From: Gary Robinson
To: [Robin Proebstring](mailto:Robin.Proebstring@mercergov.org)
Subject: FW: MICA Application
Date: Tuesday, April 4, 2017 7:58:20 AM

From: Gary Robinson [<mailto:docrobinson@comcast.net>]
Sent: Tuesday, April 4, 2017 7:45 AM
To: 'Evan Maxim' <evan.maxim@mercergov.org>; 'rovin.proebstring@mercergov.org' <rovin.proebstring@mercergov.org>; 'Scott Greenberg' <Scott.Greenberg@mercergov.org>; 'Julie Underwood' <julie.underwood@mercergov.org>; 'Kari Sand' <kari.sand@mercergov.org>
Cc: 'bruce.bassett@mercergov.org' <bruce.bassett@mercergov.org>; 'debbie.bertlin@mercergov.org' <debbie.bertlin@mercergov.org>; 'dan.grausz@mercergov.org' <dan.grausz@mercergov.org>; 'jeff.sanderson@mercergov.org' <jeff.sanderson@mercergov.org>; 'Wendy Weiker' <Wendy.Weiker@mercergov.org>; 'david.wisenteiner@mercergov.org' <david.wisenteiner@mercergov.org>; 'benson.wong@mercergov.org' <benson.wong@mercergov.org>; 'Ali Spietz' <Ali.Spietz@mercergov.org>
Subject: MICA Application

The most recent revised SEPA application by MICA received 28 March is noted. Consistent with the previous 5 submissions, MICA SEPA 02.02.2016, MICA SEPA & ZTR 06.21.2016, MICA SEPA AND ZTR 08.17.2016, MICA SEPA corr

SHEET NUMBER
C301

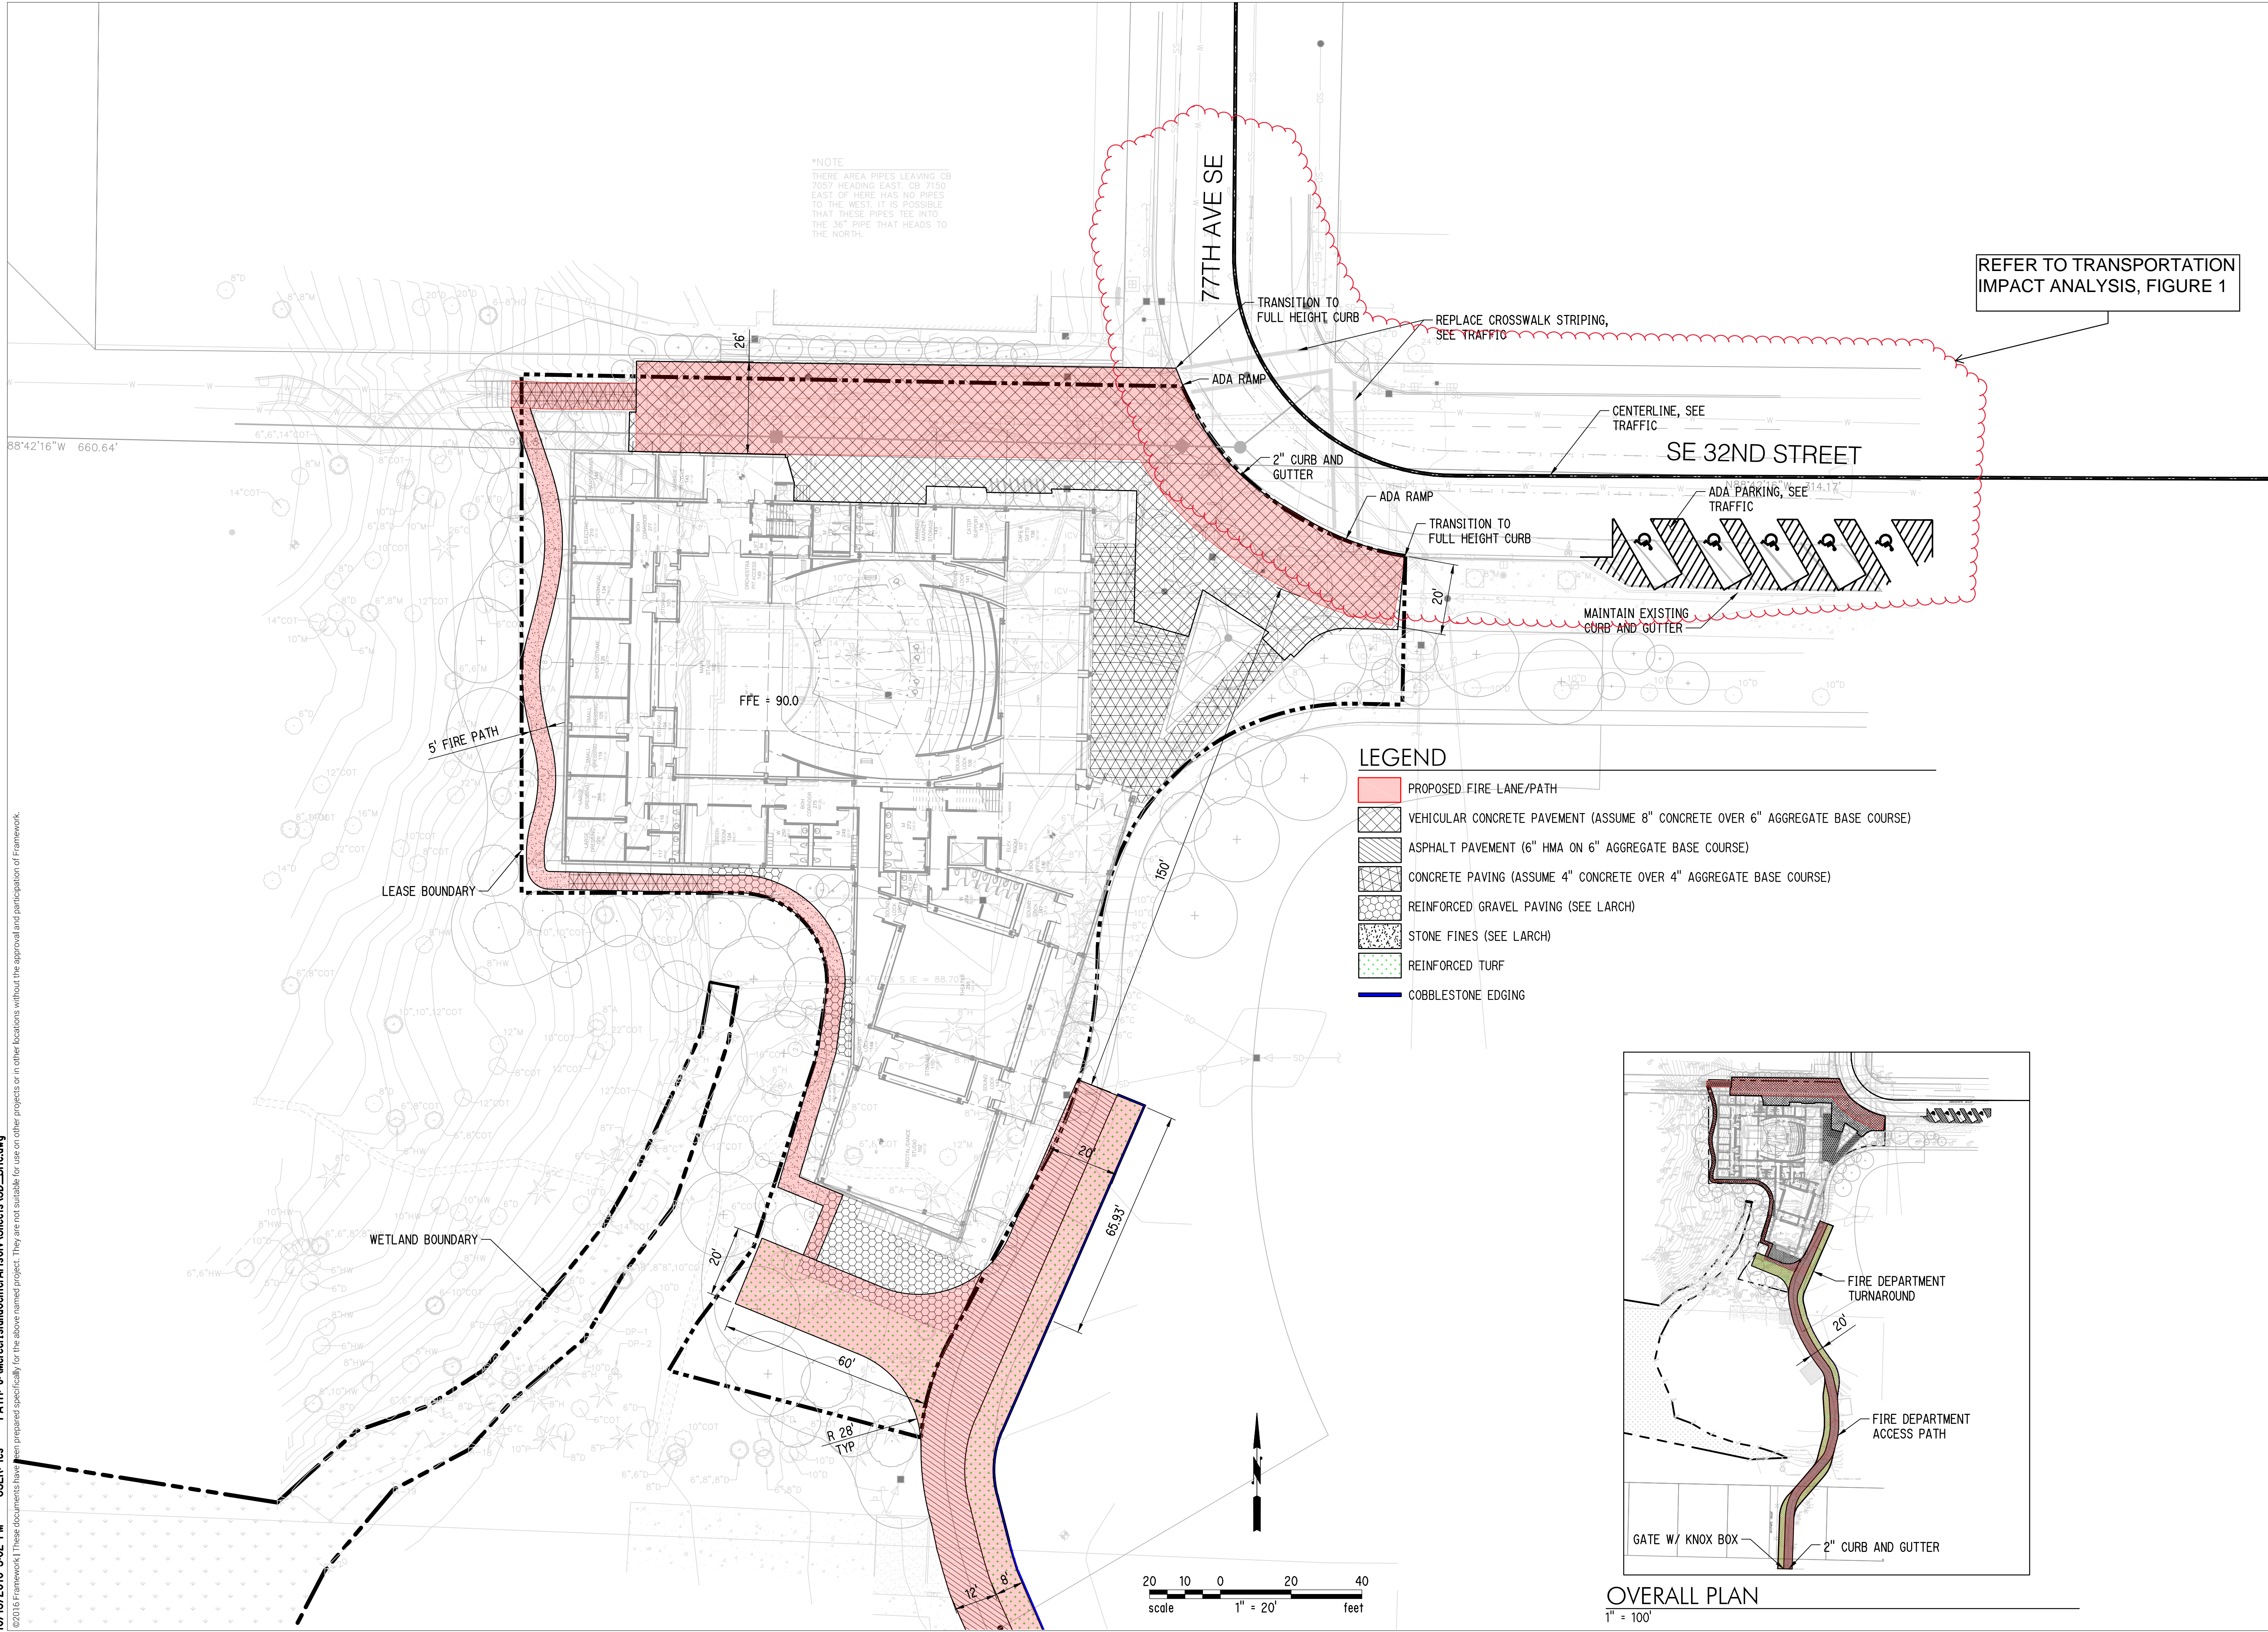
1. MICA continues to state they will do a plat "if necessary". It is our understanding they have been told they need a long plat and it is puzzling that they continue to not acknowledge this requirement.
2. We note that the detention vault has been moved to now be under the recital studio on the south end of the building. Given its

proximity to the wetlands and the skate park, does this not suggest an EIS would be in order.

3. We note that the swale location has been moved and it is not clear that this change conforms to city code and would further support requiring an EIS.
4. The drawing appears to continue showing the MICA footprint encroaching on 32nd street. No application has been made for vacation of 32nd street. Would this not be necessary before a lease could be signed?
5. The issue of fire access through Mercedale Park is yet to be addressed.
6. The issue of serving Alcohol in the park under the request for deviation to park policy has yet to be addressed
7. They have failed to address the comments regarding parking made by Patrick Yamashita
8. We don't fully understand whether an "inadequate" plan can be determined "complete"?
9. How is the 90-day lapse rule applied? How are days counted? From our perspective August 2016 to January 2017 is more than 90 days.
